Our Case Number: ACP-323980-25

Re: Proposed Water Supply Project for the Eastern and Midlands Region
in the counties of Clare, Limerick, Tipperary, Offaly, Kildare, and Dublin.

Formal Objection to the Proposed Water Abstraction Project

Lough Derg Anglers Association Submission

Drawing Title: Figure 4.62 RAW WATER INTAKE AND PUMPING STATION AT PARTEEN BASIN ACCESS ROAD

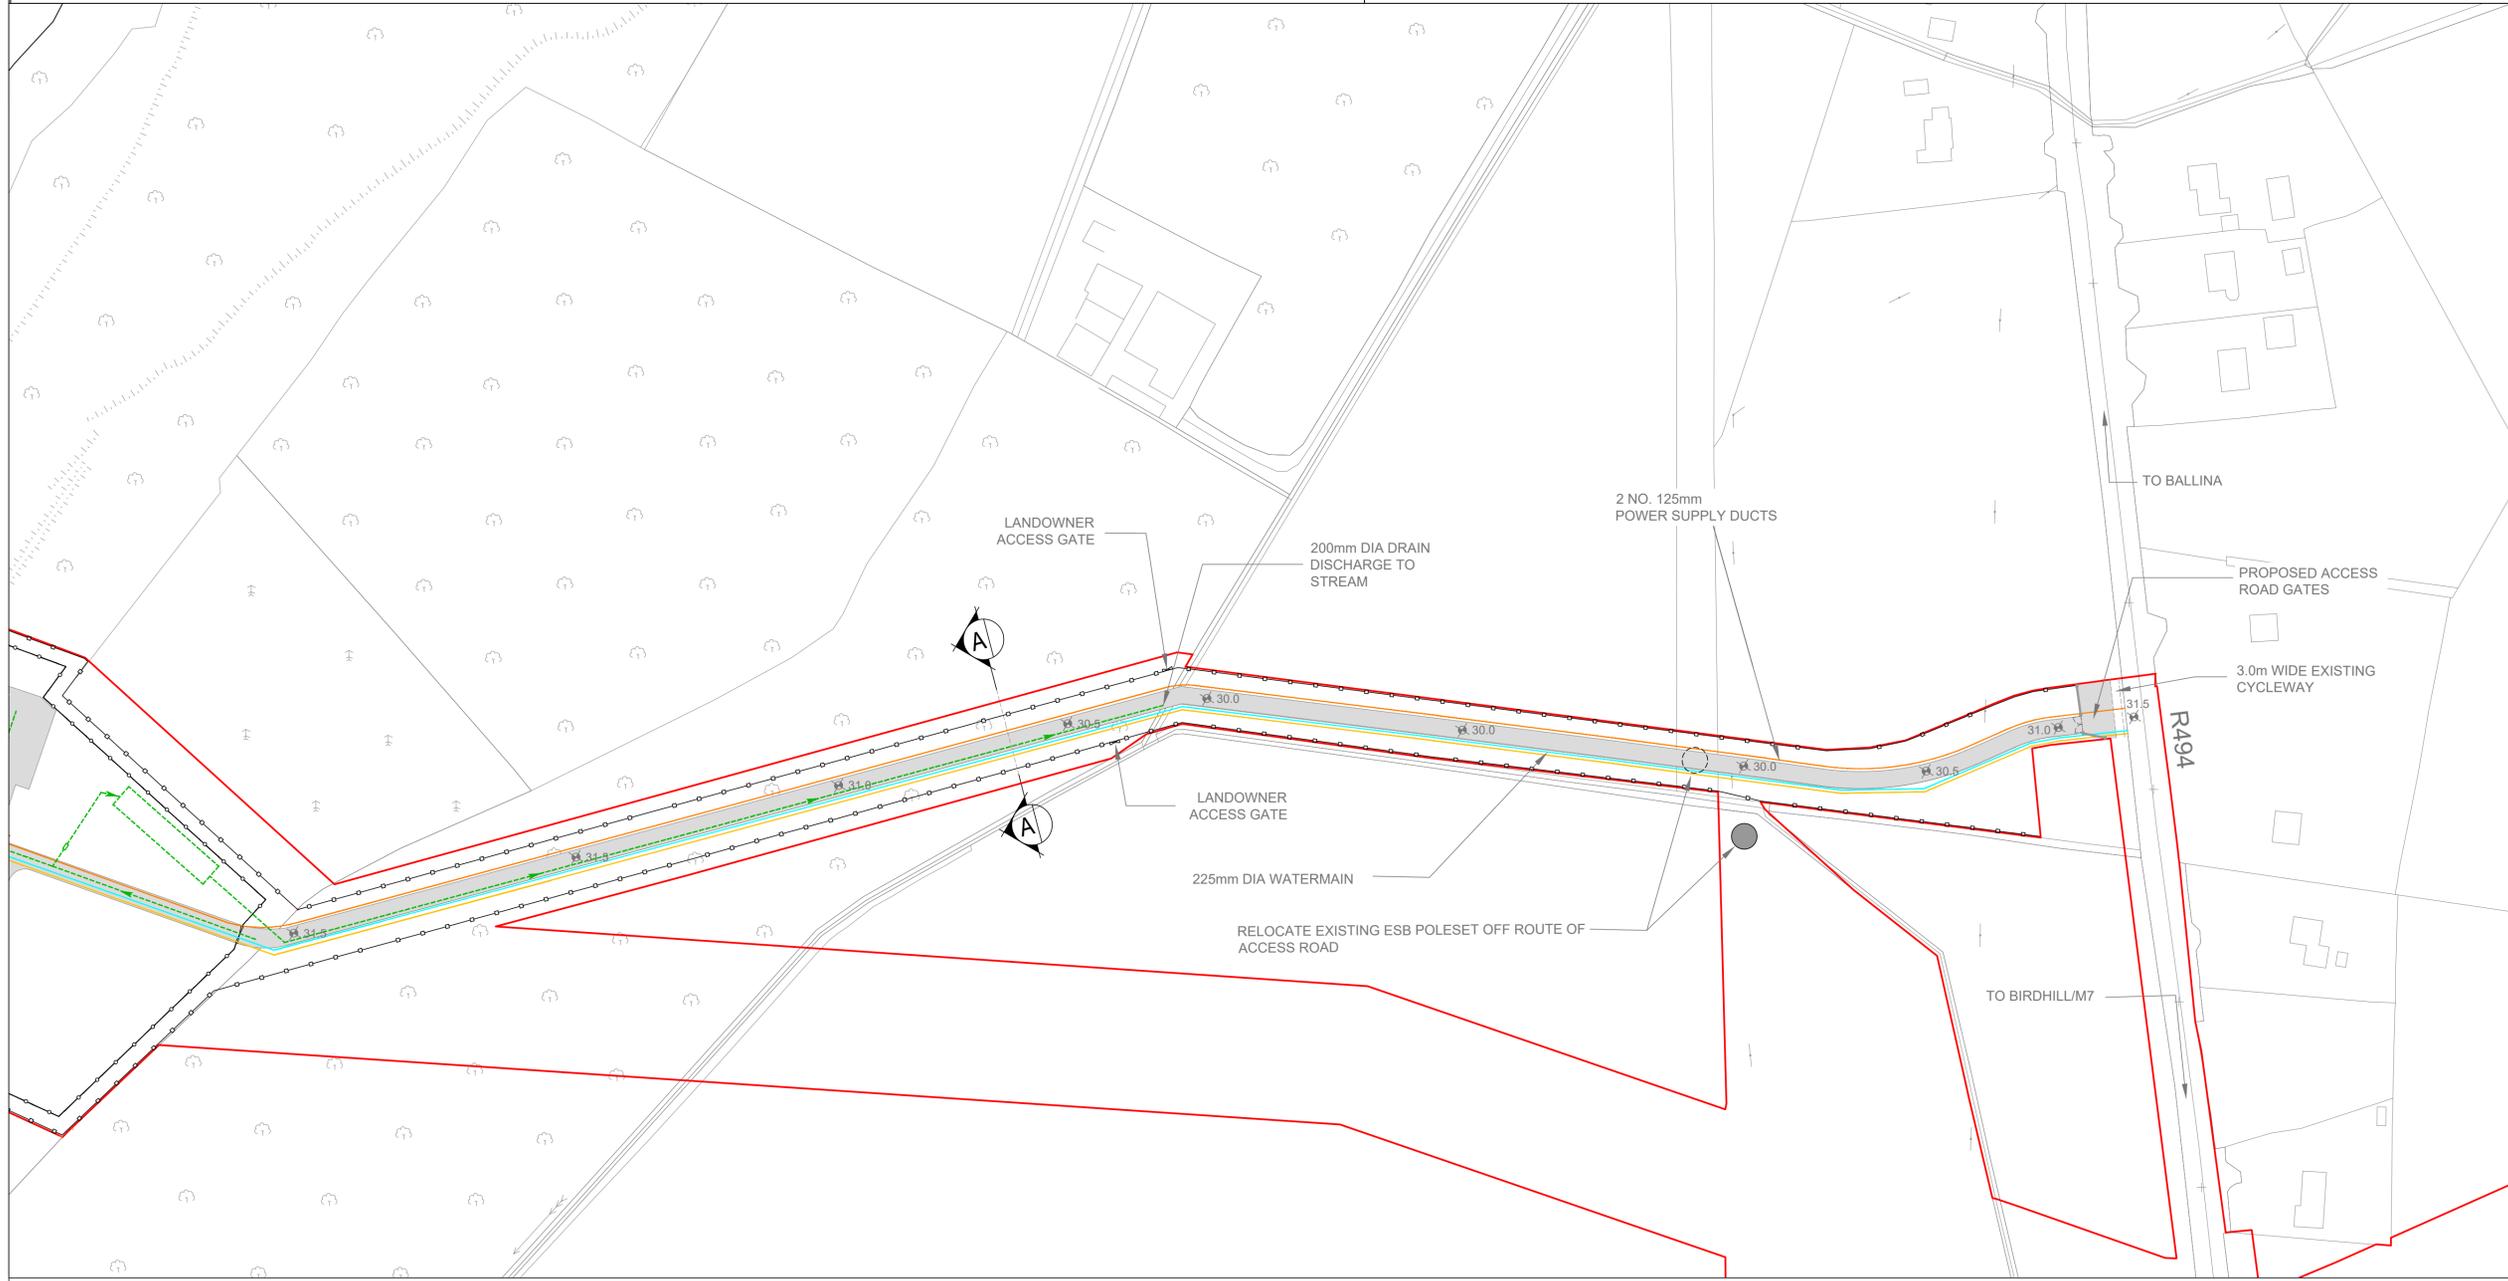
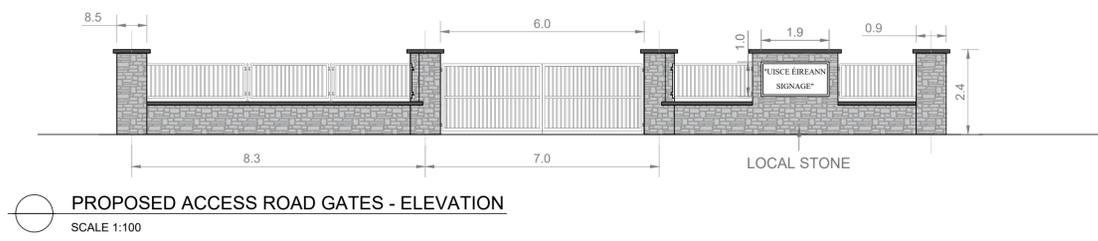
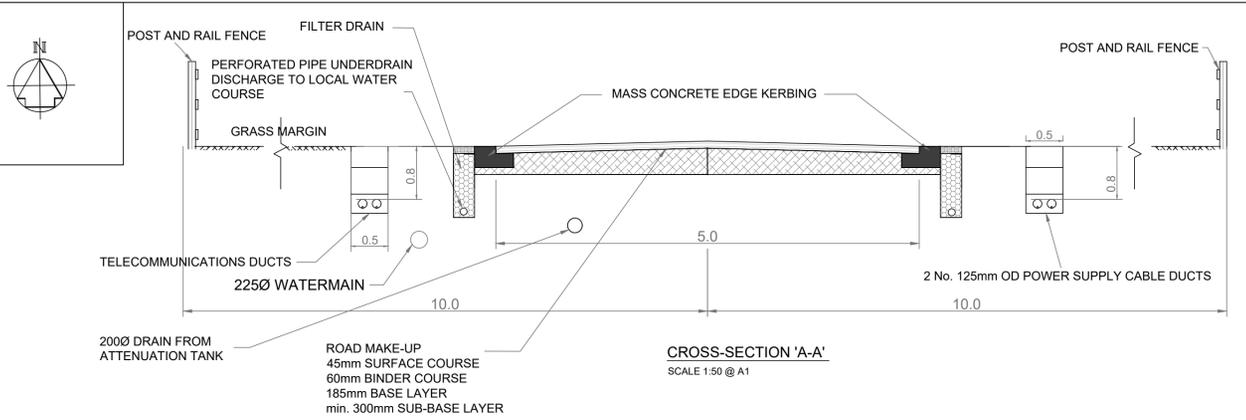
Consent under Article 6(3) of the Habitats Directive requires certainty that the development will not adversely affect the integrity of the Lower River Shannon SAC. The project presents a significant risk to spawning beds in the northwest lower lake, notably for bream, tench, roach, and pike, located merely 100 meters opposite the raw water intake pipes.

The alteration of natural flow patterns impacts retention necessary for migratory fish. The positioning of the intake is a particular concern, being at the final holding pool for migratory and juvenile fish in the Parteen basin—a critical area before migration into Lough Derg.

13. In the proposed restricted zone on the Shannon (100mx25m of buoys), we propose attaching a mesh from river bed to buoys as a secondary measure to prevent migration of fish toward artificially generated flows.

A 100-meter section of native woodland at the abstraction point will be directly impacted and removed, fragmenting shoreline ecology and worsening hydrological pressures within the Lower Shannon system. This woodland fulfills important ecological functions:
